Ribble Valley Borough Council  
Housing & Development Control

Application no: **3/2023/0992**

Address: **Healings Farm West Bradford Road Waddington BB7 3JE**

Proposal: **Prior notification for the demolition of existing workshop building and replacement with one new single-storey dwelling with basement, including landscaped gardens, access and parking.**

# Site plan as proposed 1:500 @ A3

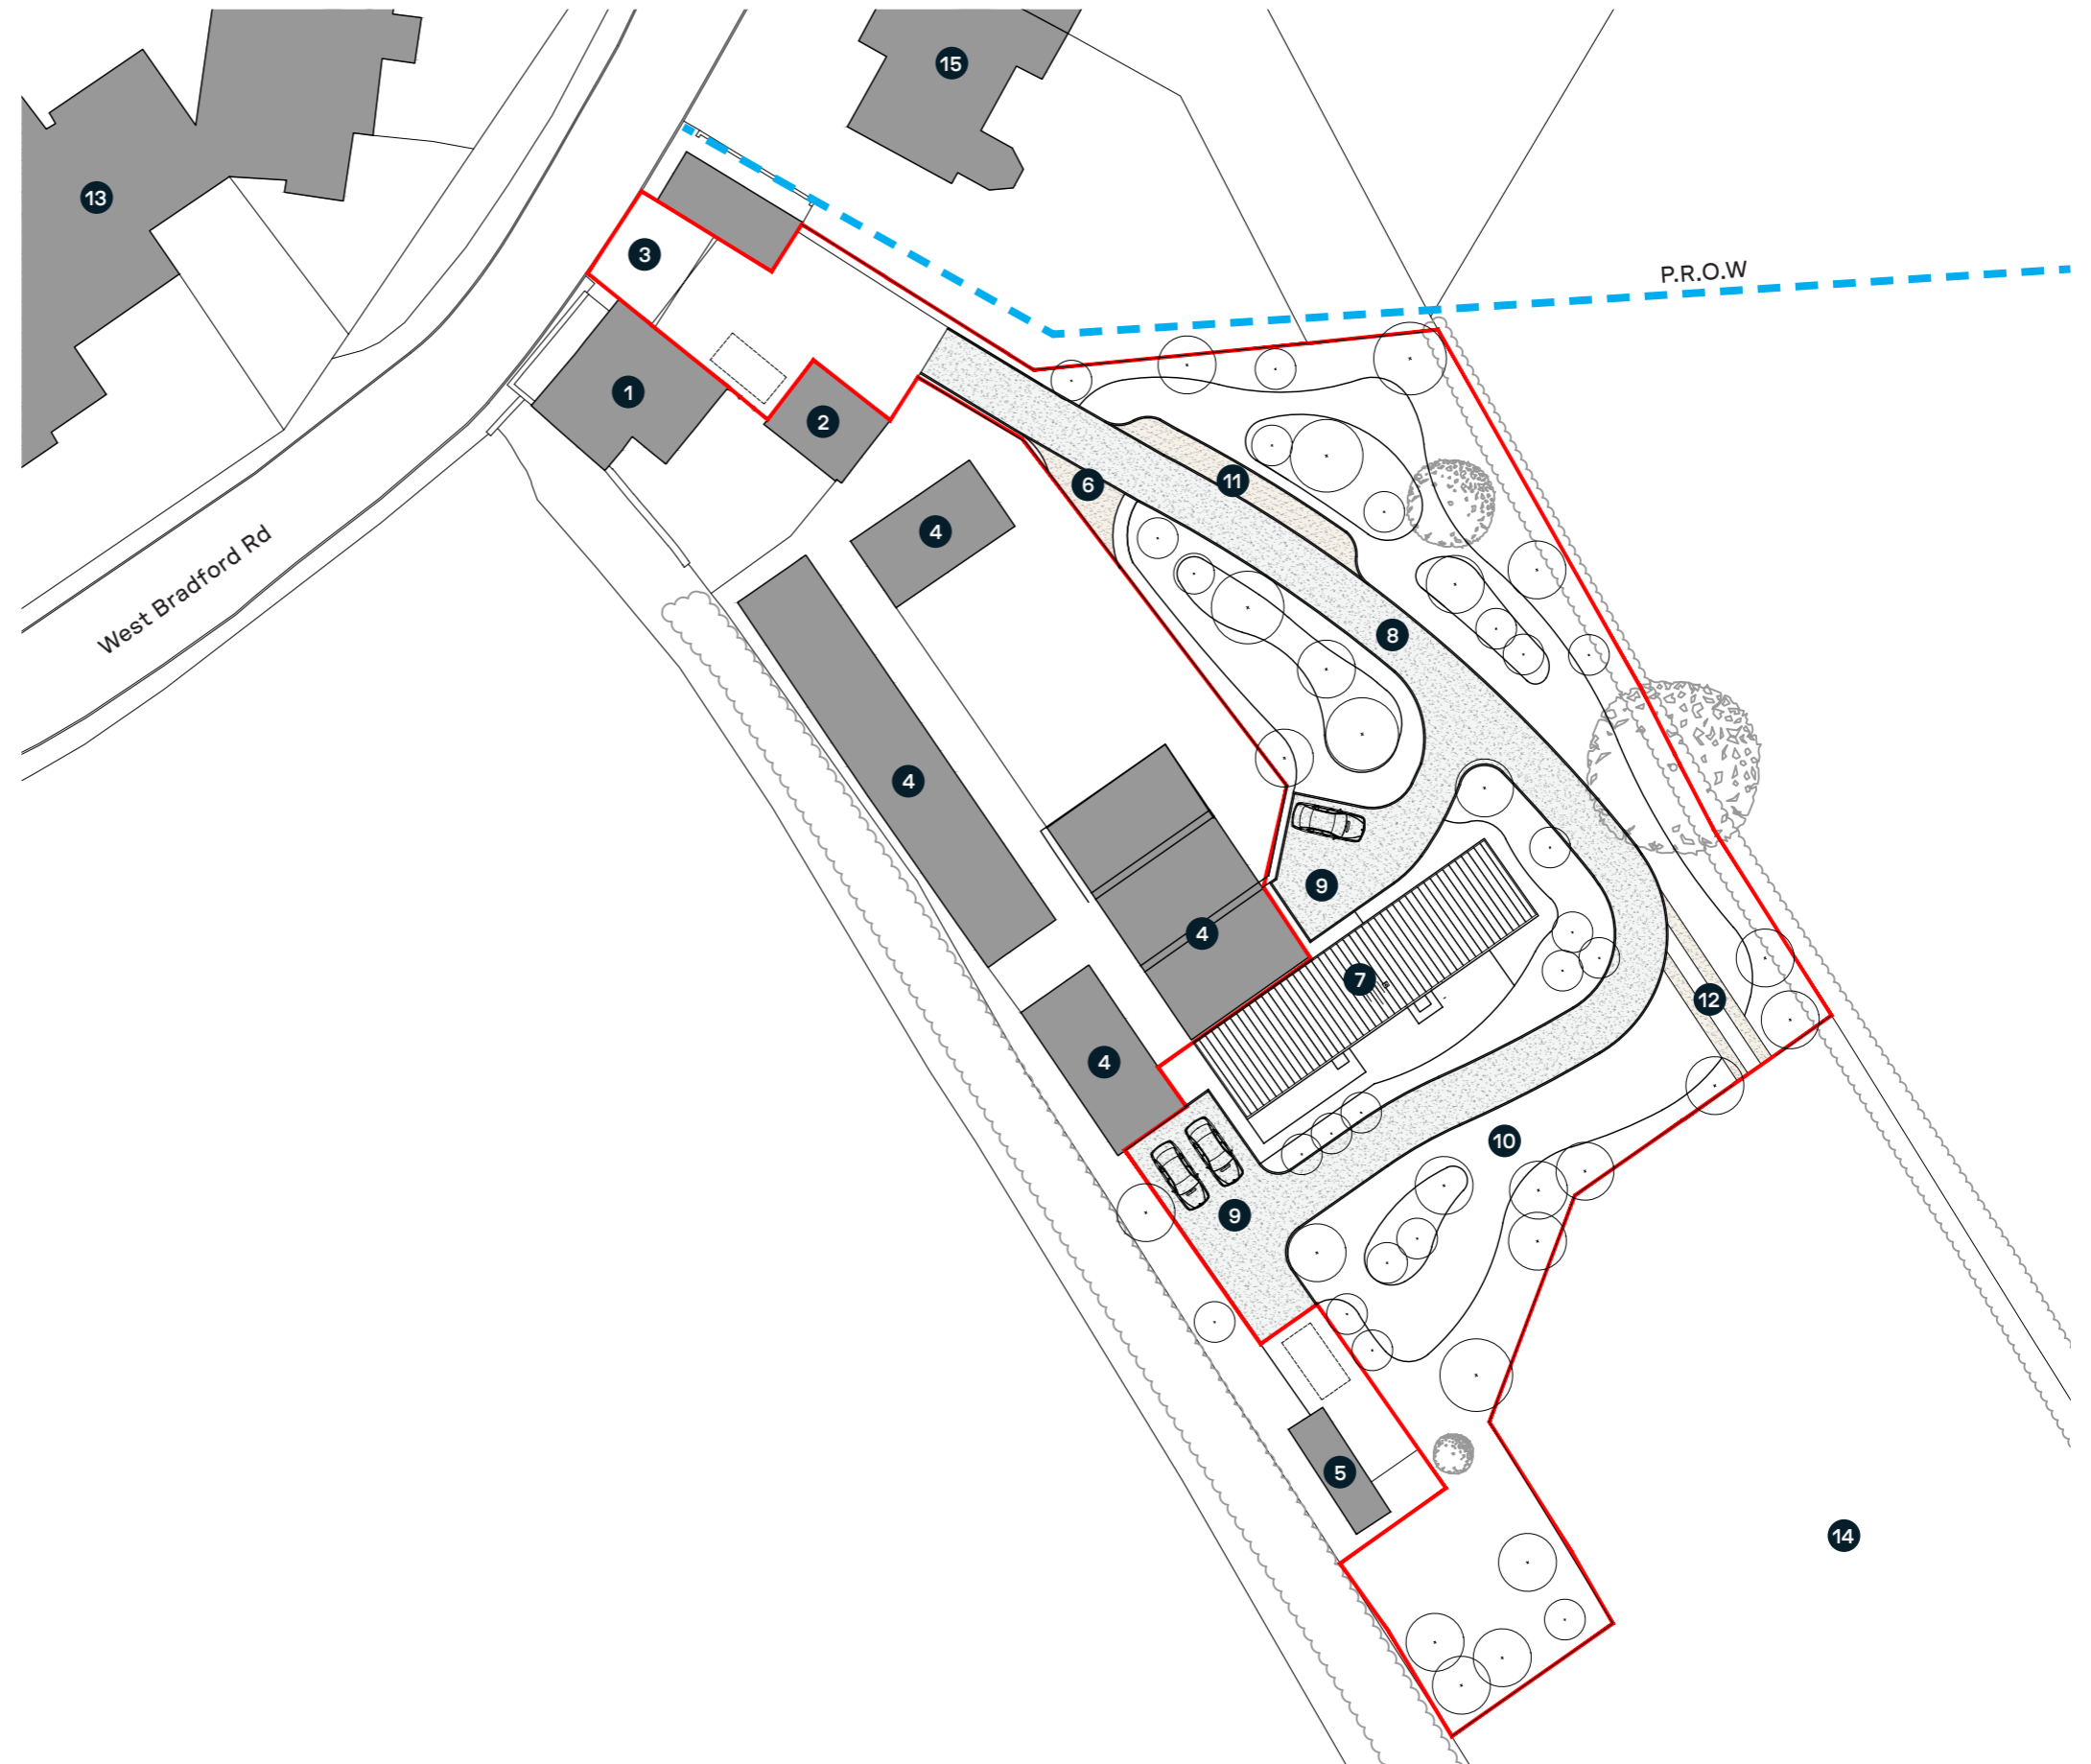
The LHA have reviewed Rural Solutions drawing titled "Site Plan As Proposed" and are aware that the existing access will remain unaltered as part of the application. Given that the existing use of the workshop generated trips in its own right and are likely to be similar to the number of trips which will be generated to the proposed dwelling, the LHA have no further comments to make regarding the site access with the proposal not being seen as an intensification of use.

The LHA have reviewed Rural Solutions drawing titled "Site Plan As Proposed" and are aware that 3 car parking spaces will be provided for the 4 bed dwelling which complies with the parking guidance as defined within the Joint Lancashire Structure Plan. .

Furthermore, the LHA have reviewed Rural Solutions drawing titled "Site Plan As Proposed" and are aware that the proposal is aiming to formalise an access track which will serve the site. The proposed access track which connects to the site access and serves the agricultural field, two dwellings (including the one proposed) and a number of buildings which are used for light industrial, will be 3.5m wide which complies with the LHAs guidance. The LHA also welcome the introduction of a passing place along the track.

2. No part of the development hereby permitted shall be occupied until such time as the access and access track arrangements shown on Rural Solutions drawing titled "Site Plan As Proposed" have been implemented in full.

3. The development hereby permitted shall not be occupied until such time as the parking and turning facilities have been implemented in accordance with Rural Solutions drawing titled "Site Plan As Proposed". Thereafter the onsite parking provision shall be so maintained in perpetuity.

# Construction management plan

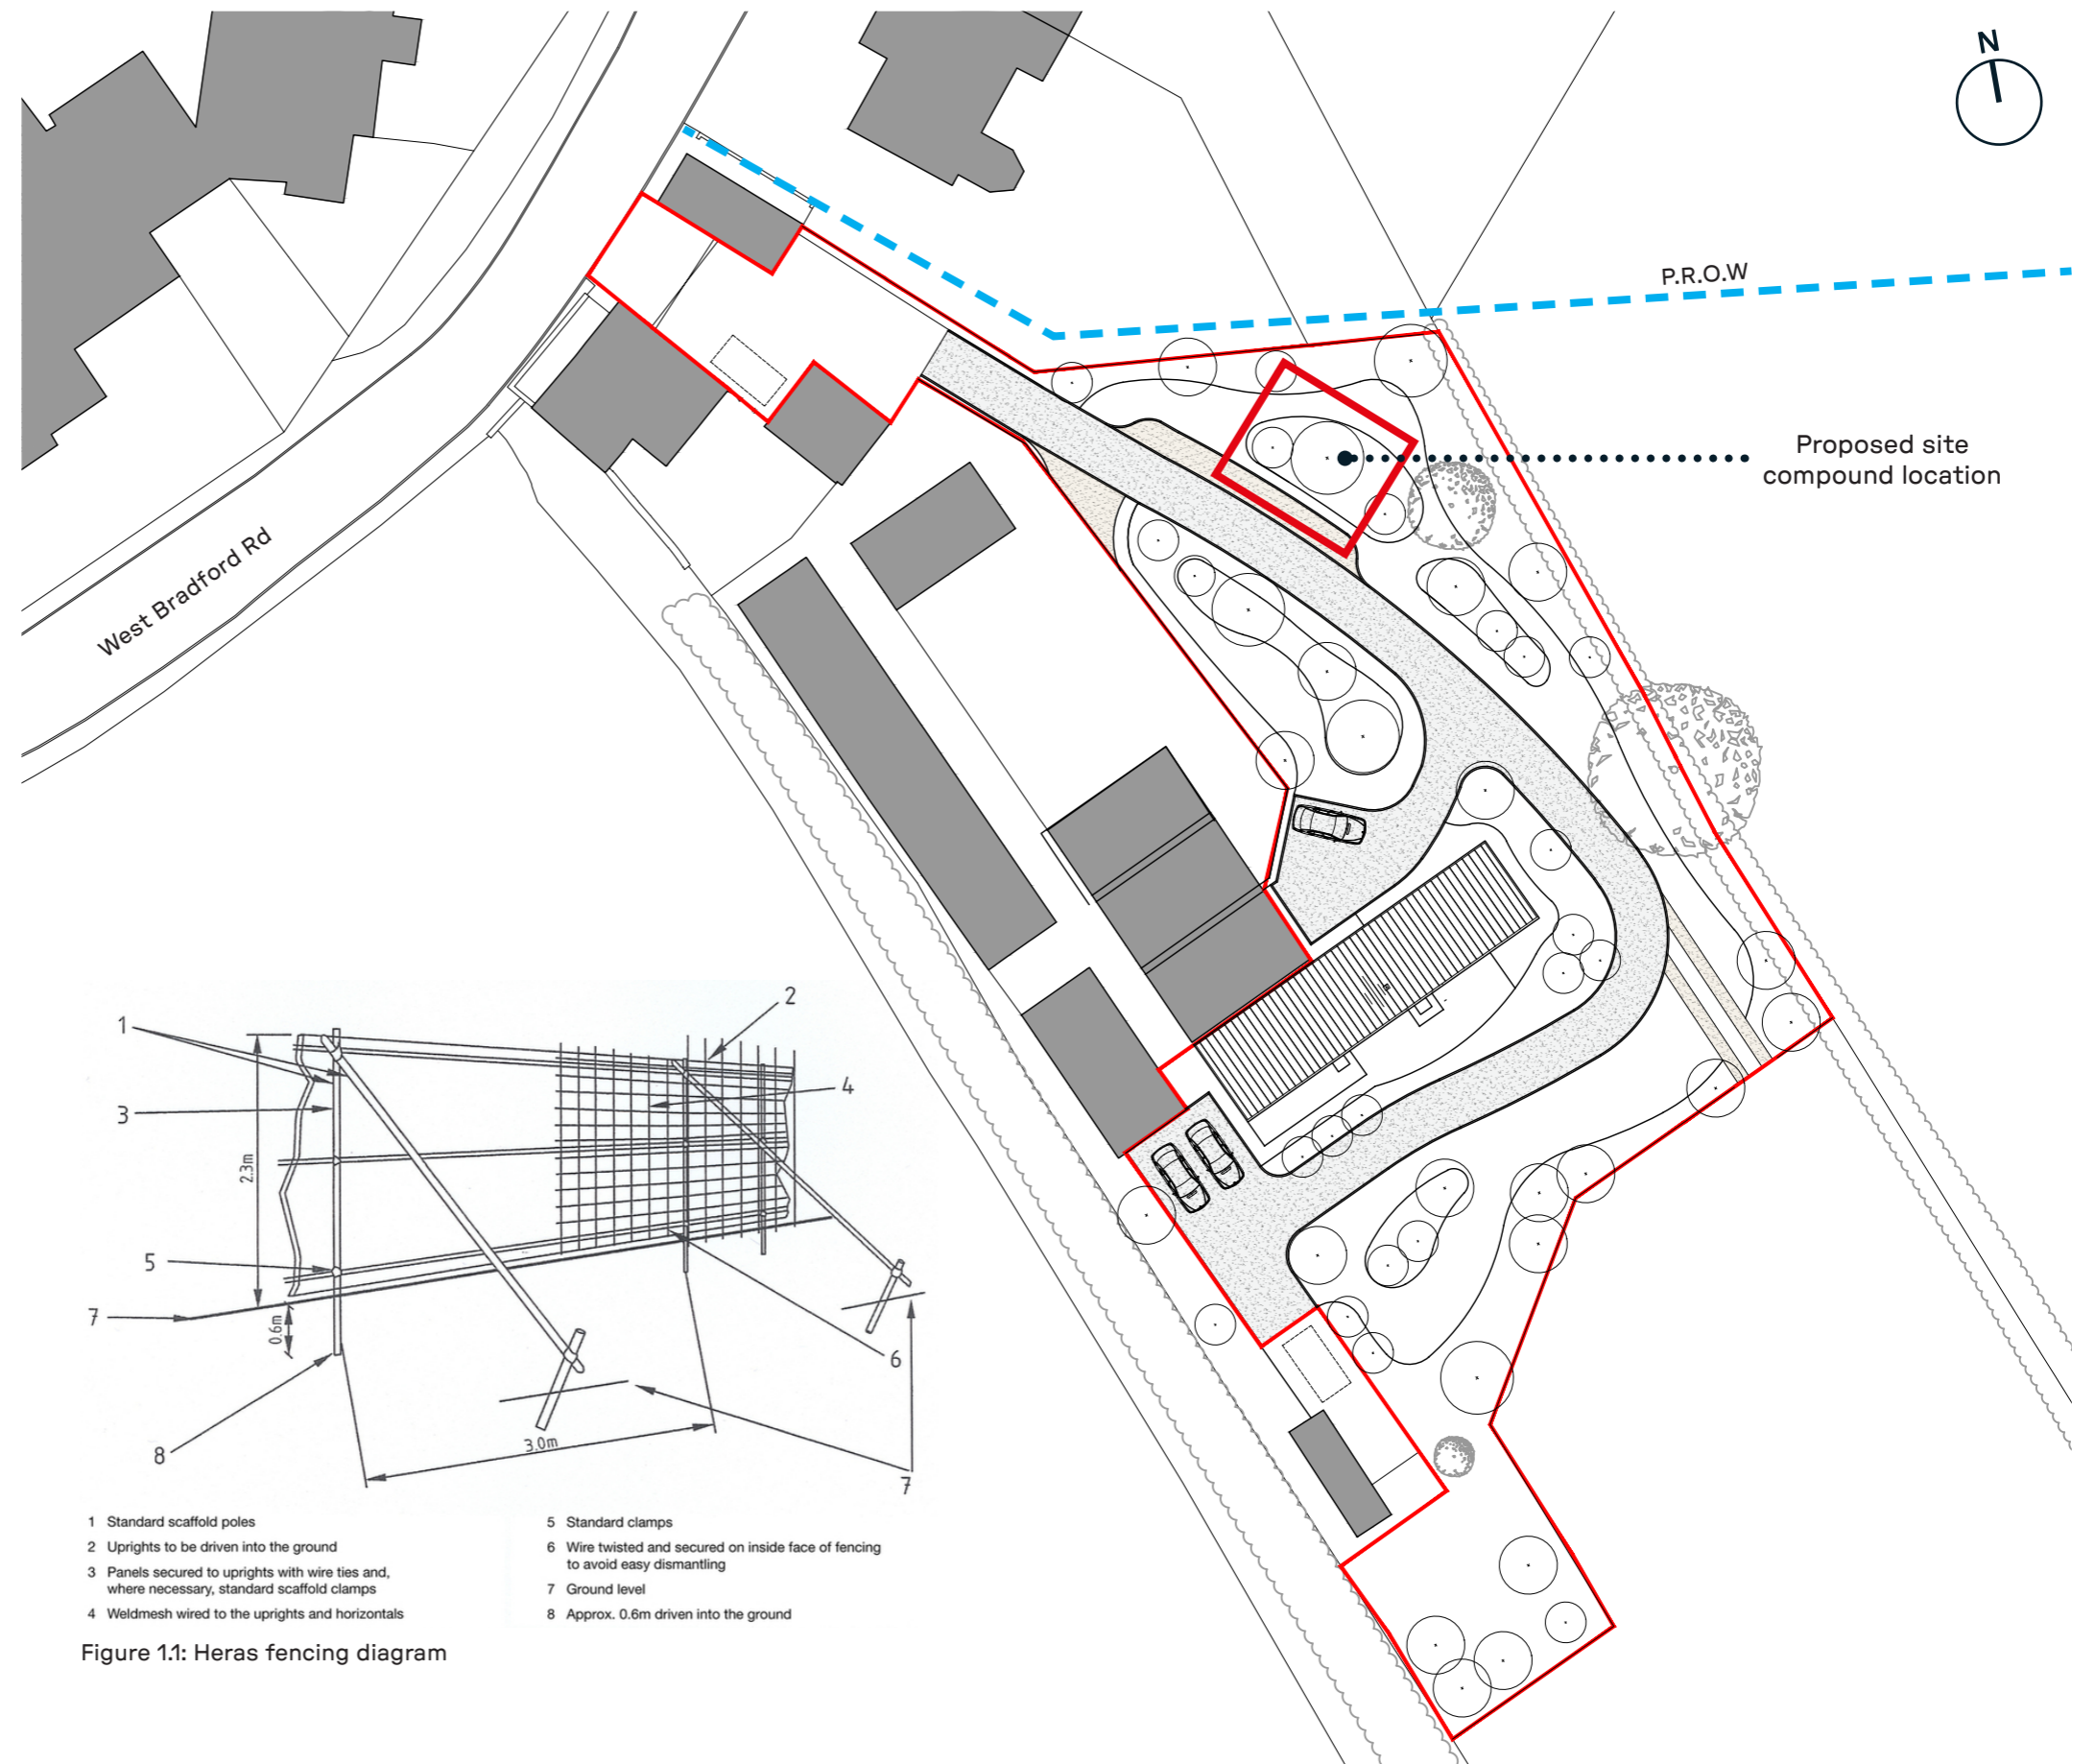
A construction management plan is submitted and is considered acceptable for the proposal.

1. The construction of the development shall be carried out in accordance with the Construction management plan.
